KITTITAS COUNTY DEPARTMENT OF PUBLIC WORKS

MEMORANDUM

TO: Jeff Watson, Community Development Services
FROM: Christina Wollman, Planner II *CW*
DATE: December 9, 2010
SUBJECT: Baker BL-10-00047

NOT TO SCALE

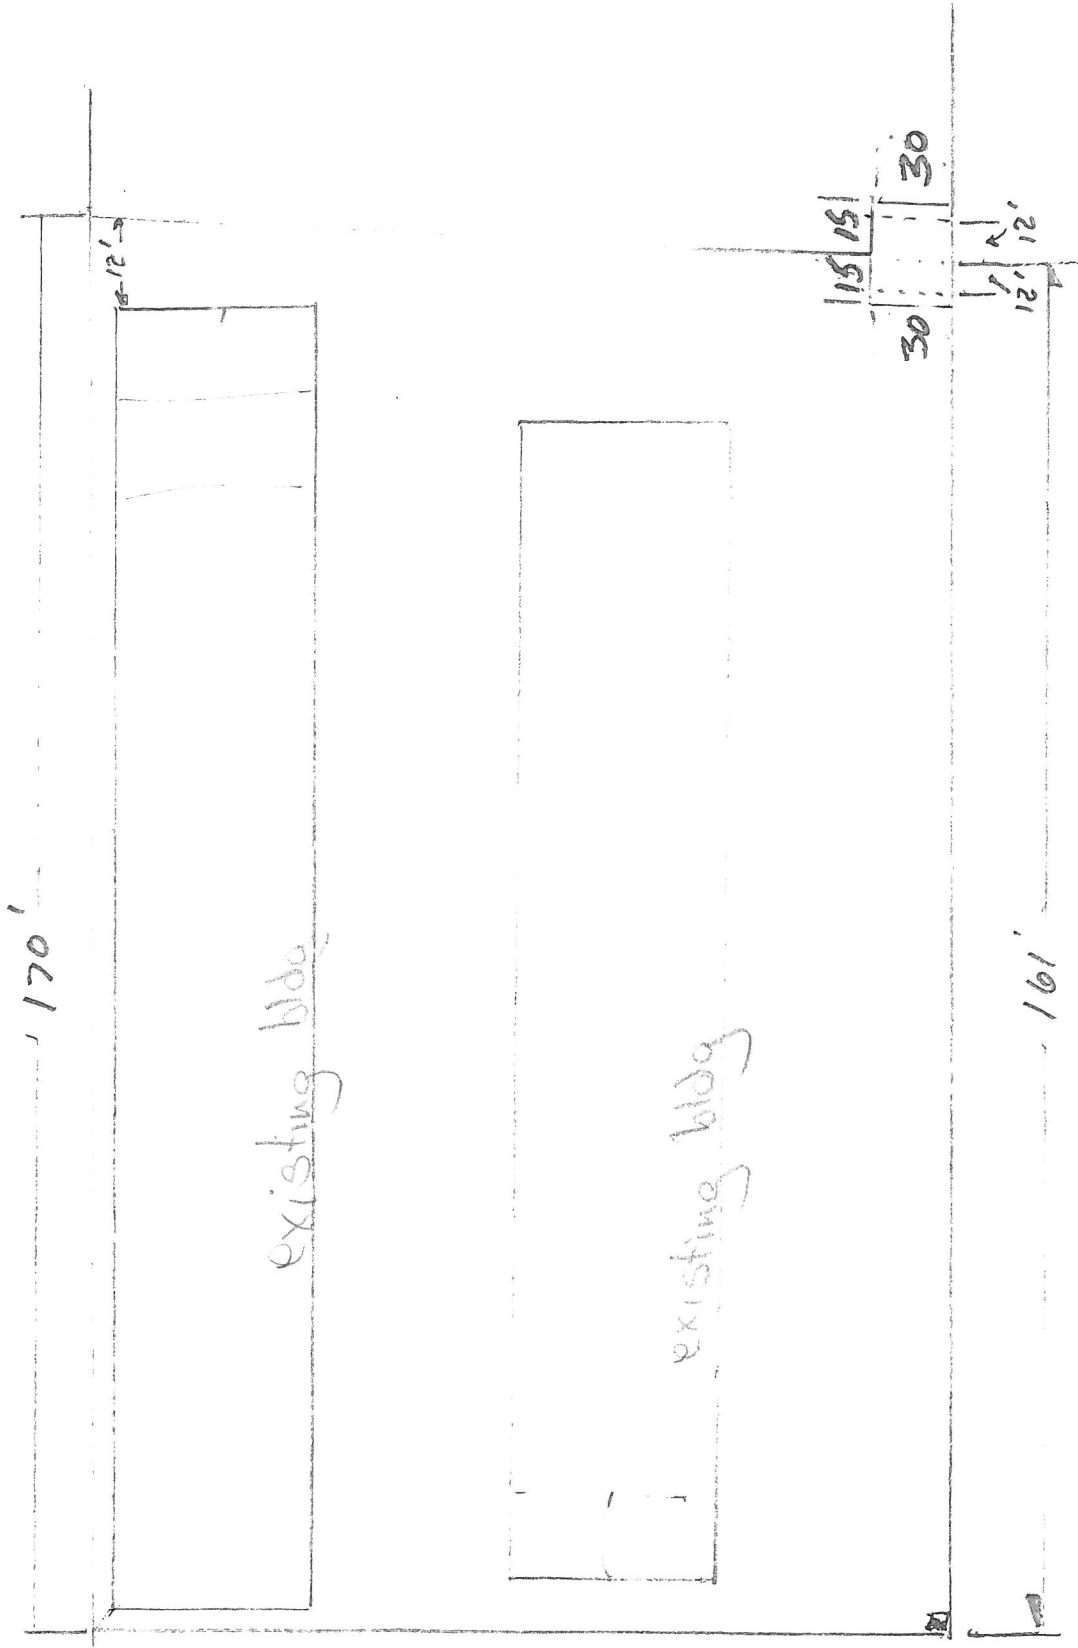
1. The proposed access easement shall be sufficient to allow unobstructed and legal access onto each lot.
2. A revised legal description that describes the final configuration of the subject property shall be required.
